**KIRKLEES METROPOLITAN COUNCIL
INVESTMENT & REGENERATION SERVICE**

DELEGATED DECISION TO DETERMINE PLANNING APPLICATIONS

Reference No:	2023/62/91207/E
Site Address:	73, Bunkers Lane, Staincliffe, Batley, WF17 7QT
Description:	Erection of extensions and alterations
Recommending Officer:	Jennifer Booth

OFFICER REPORT

PROPOSED ELEVATION TO FRONT

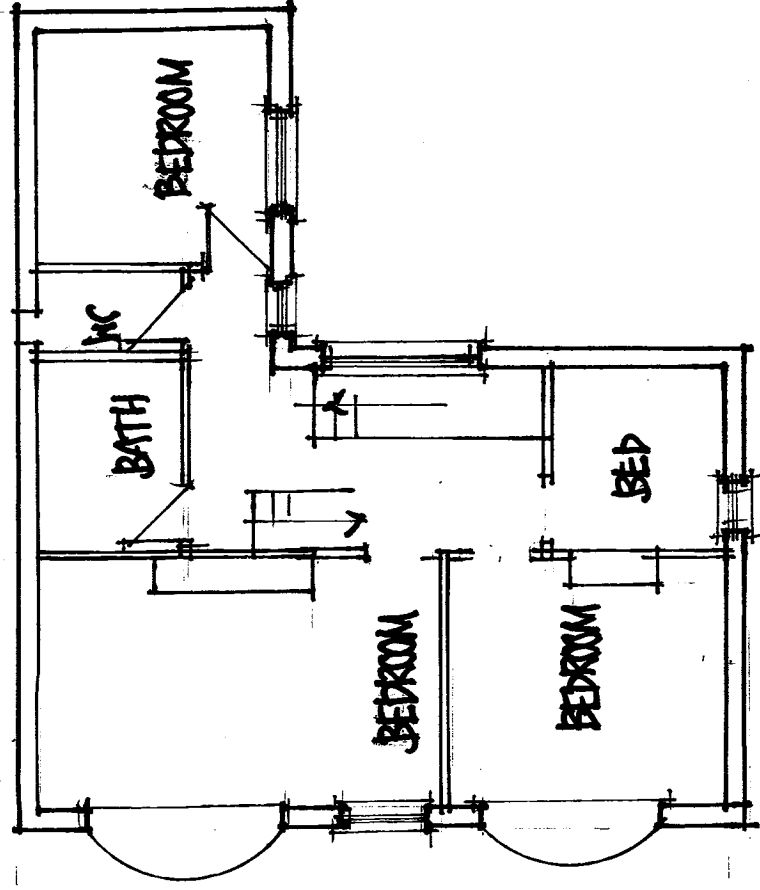
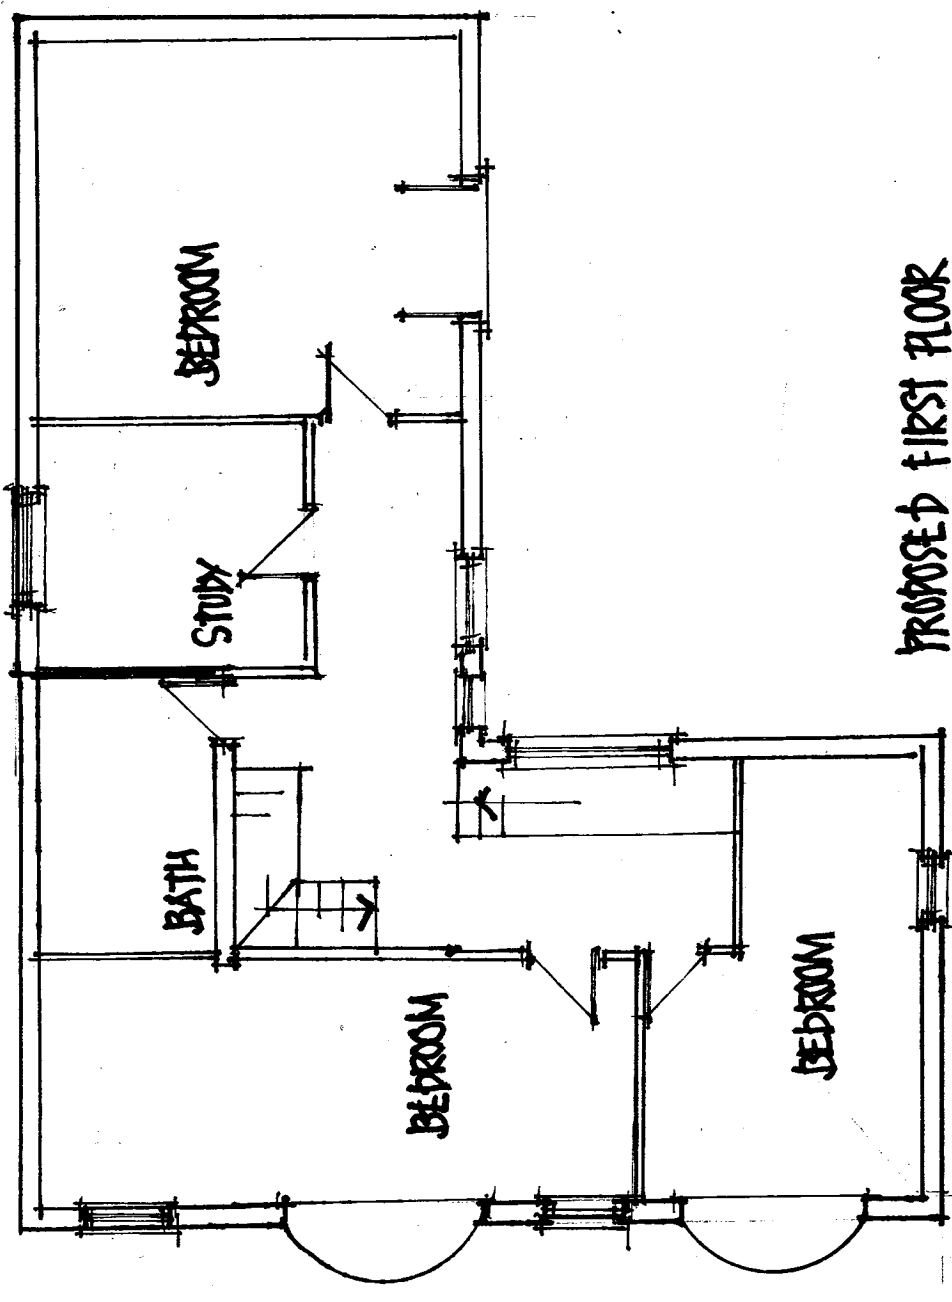
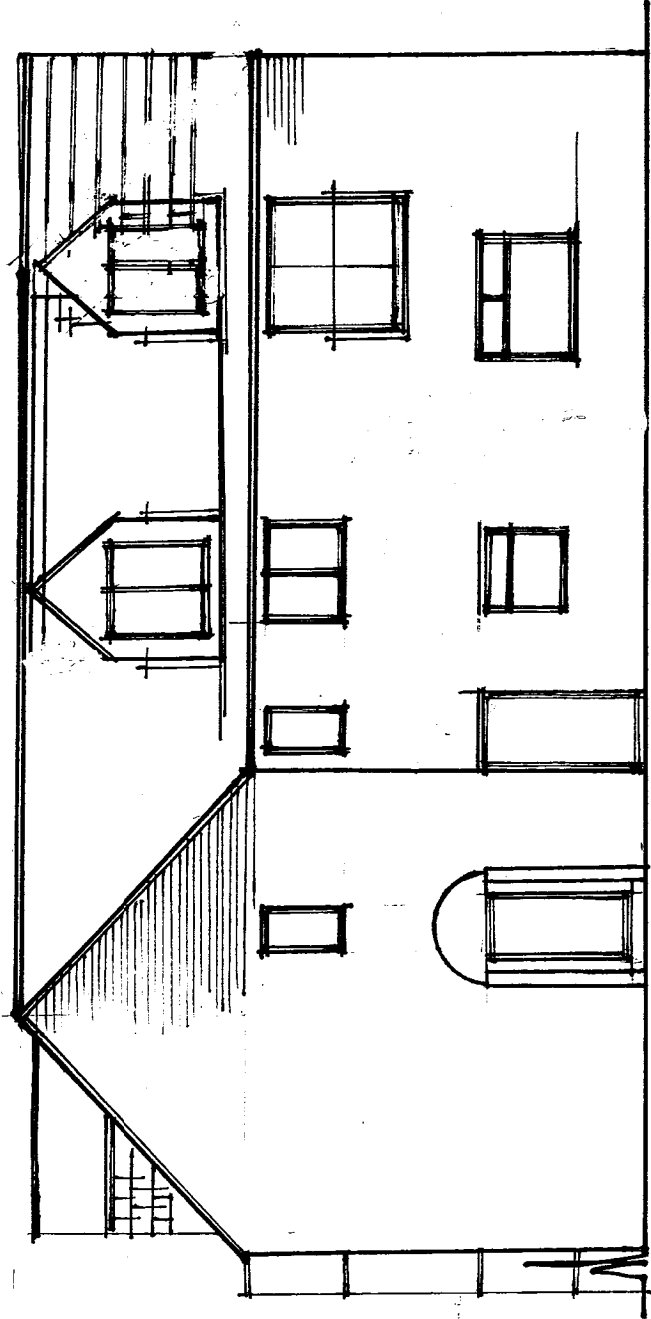
The initially submitted plans raised issues in terms of the design, in particular for the side extension, with a blank front elevation and no set back which would have resulted in an unsympathetic addition. Amended plans have been received during the course of the application and have included windows, which improve the appearance. As the alterations are minimal, the amended plans have not been advertised.

PROPOSED FRONT

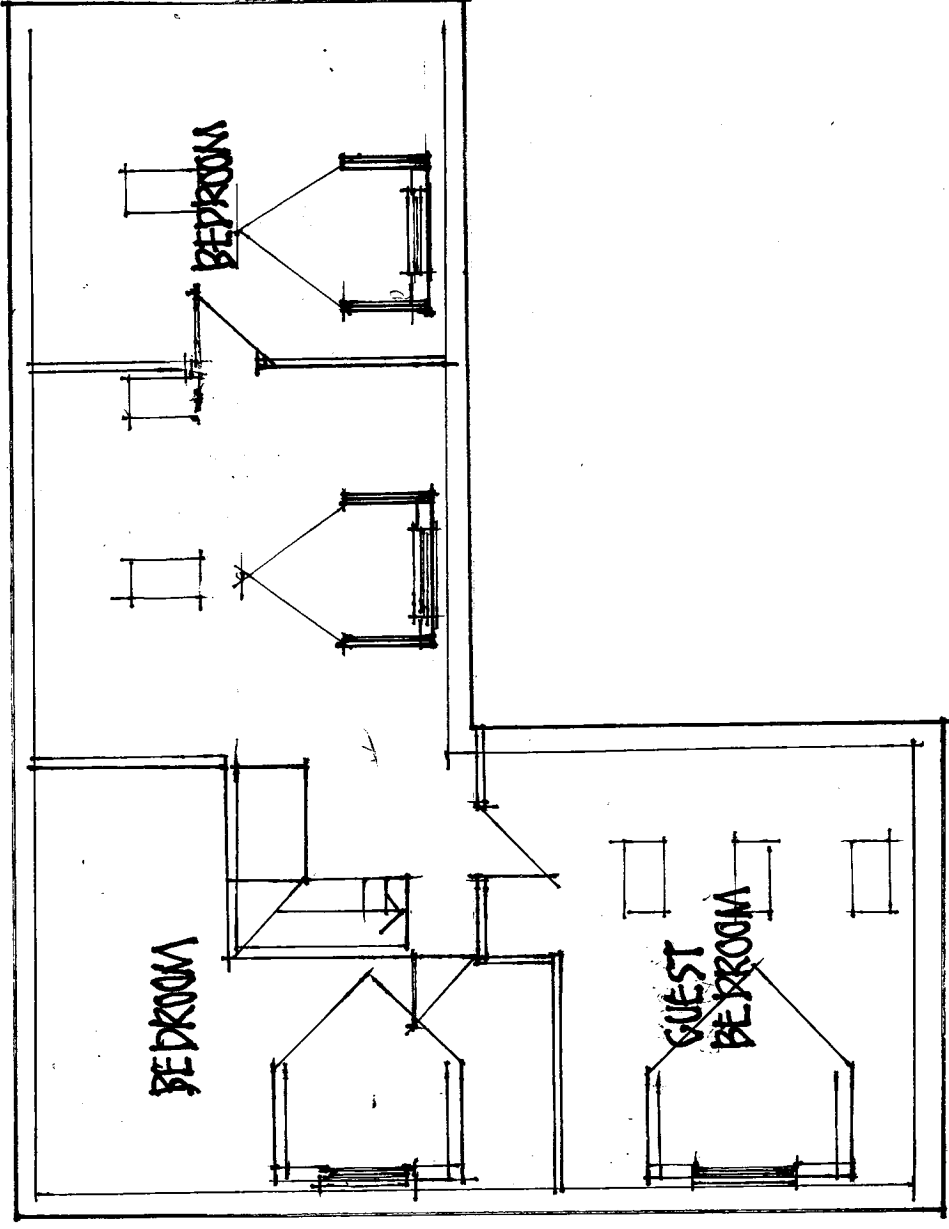
The front dormers would have a width of 2.7m with a height of 2.5m, the roof forms would be pitched and the dormers would align over the bay windows below.

The front dormers proposed would allow the main roof to remain the dominant feature. The use of vertically hung tiles allows the dormers to form a more organic relationship with the roof slope. The front dormers are therefore considered to be acceptable in terms of visual amenity.
